**Re: Development Application SSD 8373 – Alexandria Park Community School Redevelopment, Park Road, Alexandria 2015**

I am writing to voice my concerns over some elements of the proposed redevelopment of Alexandria Park Community School, Park Road, Alexandria.

3 WINTER 3PM
1 : 1000

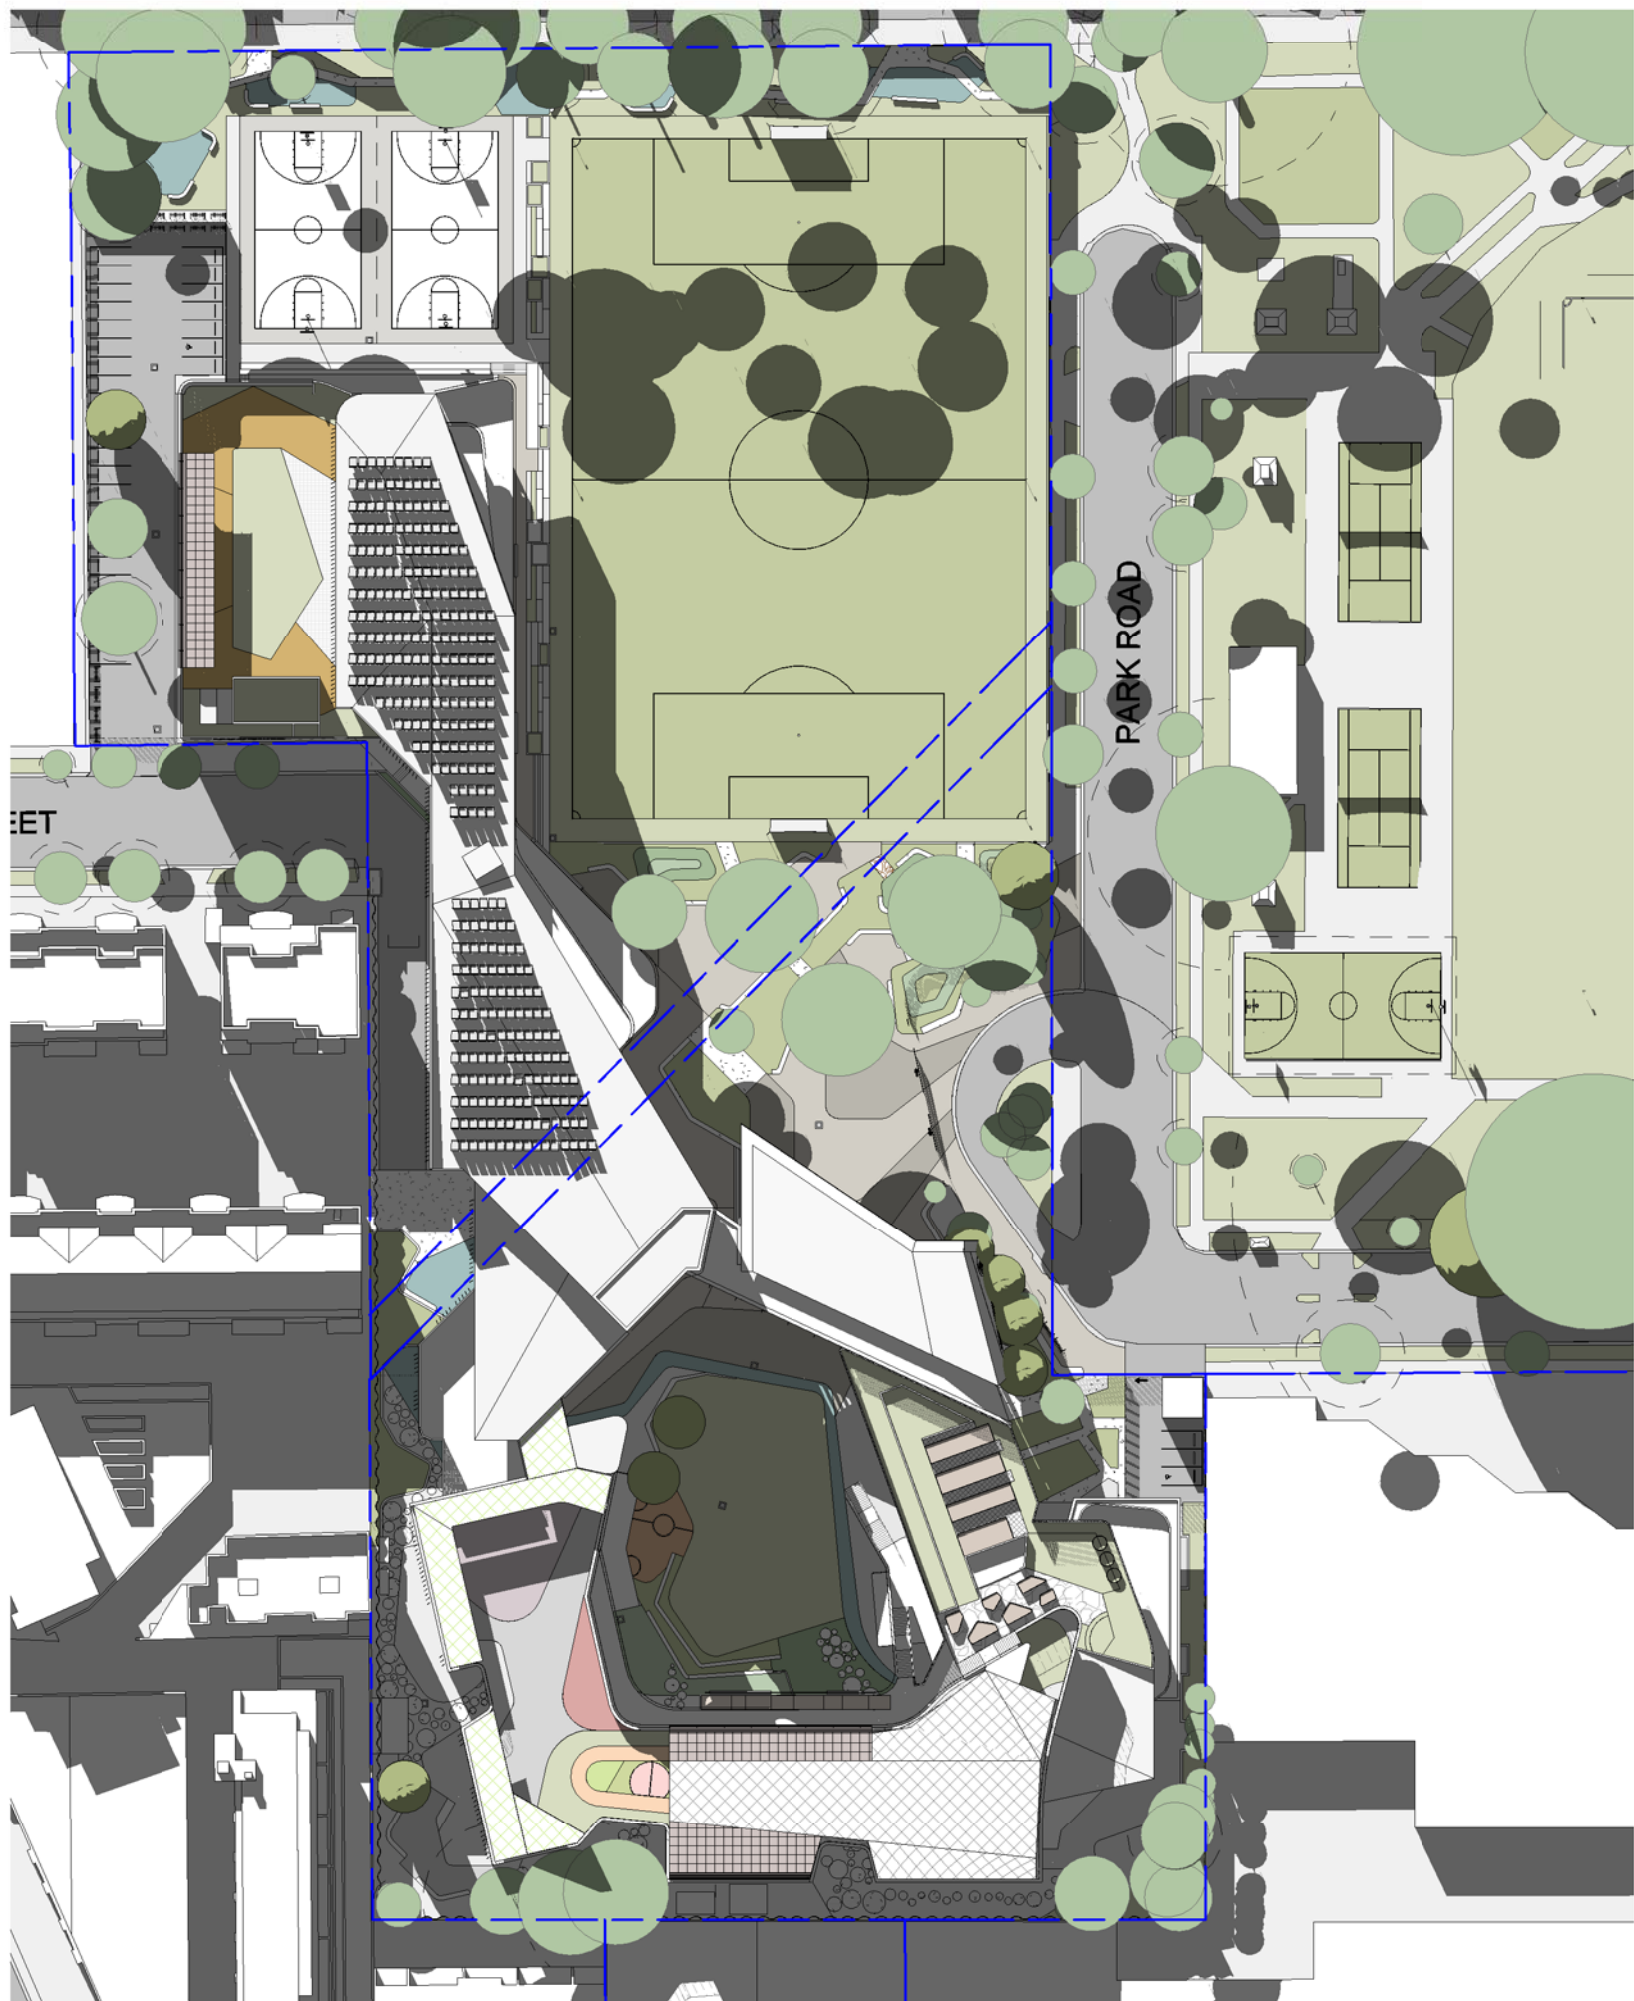
The 15 units in 141-143 McEvoy Street on the southern boundary all have living areas & outdoor areas facing north and the impact on of the overshadowing has not been properly assessed. The documents currently notes the buildings along the south perimeter as commercial which is not correct. There are **no shadow elevational diagrams** at all on Drawing No. AR.DA.5002 P1 for 141-143 McEvoy Street which is a residential property & therefore as my understanding is, is required to be taken into consideration.

The shadow plans show that the southern properties will have all sunlight removed at ground level. Has the lowered level of my property and the 5 adjacent properties been taken into consideration in the assessment?

ROOF TOP GARDENS

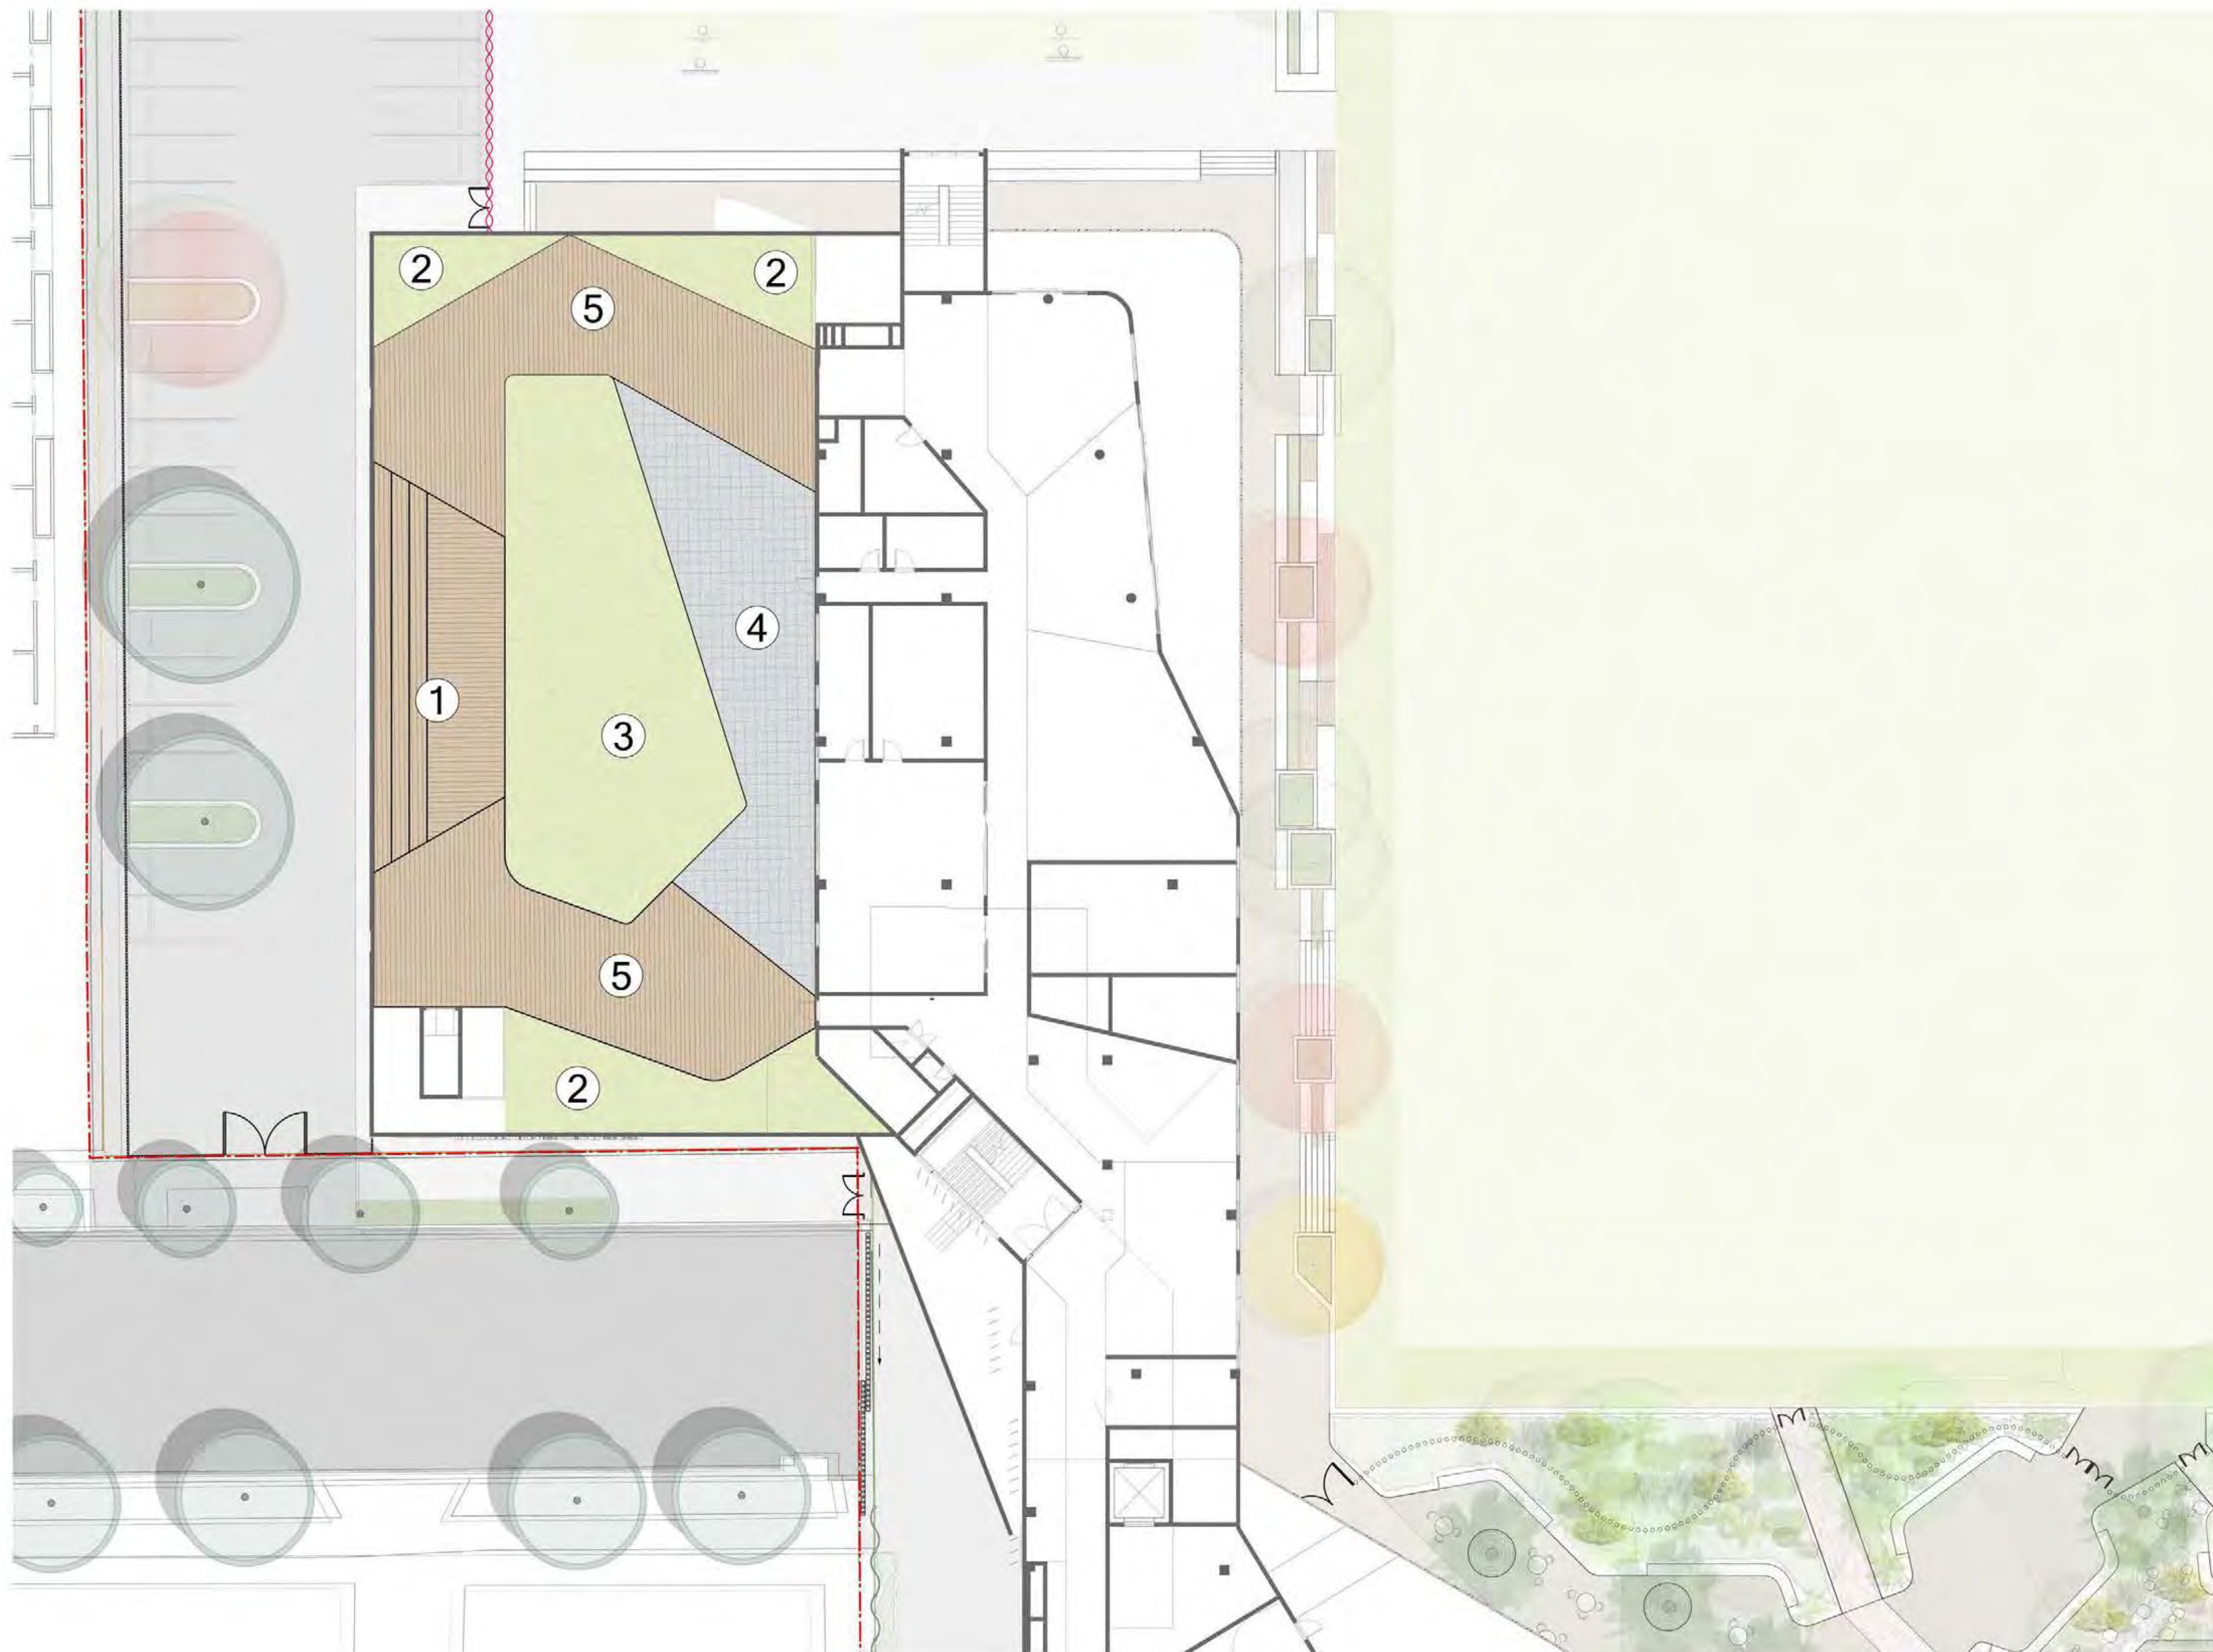
playground' which itself has a roof, this actually makes it 4 storeys. ***The living areas of my property and the 5 adjacent units actually sit approx 2.4m below the ground level of the school increasing the impact of the height of the new school in relation to my property. I seek the removal of the 'rooftop playground' due to the impact on privacy.***

The Environmental Impact Statement states the "impact will be minor" which I disagree with, the proposed buildings along the southern boundary are excessive in density & in height, the roof top playground alone is over 2000sqm in area alone. We seek the removal of the roof top play area to reduce the height and mass of the facade.

Noise generation poses a significant loss of amenity to the southern and western residents. For that reason, we request the removal of the ground level 'canopy class room' on the southern corner and the removal of the rooftop playground on the southern hub.

I would like assurance that no activities will take place on the rooftop beyond school hours of 9am-3.30pm.
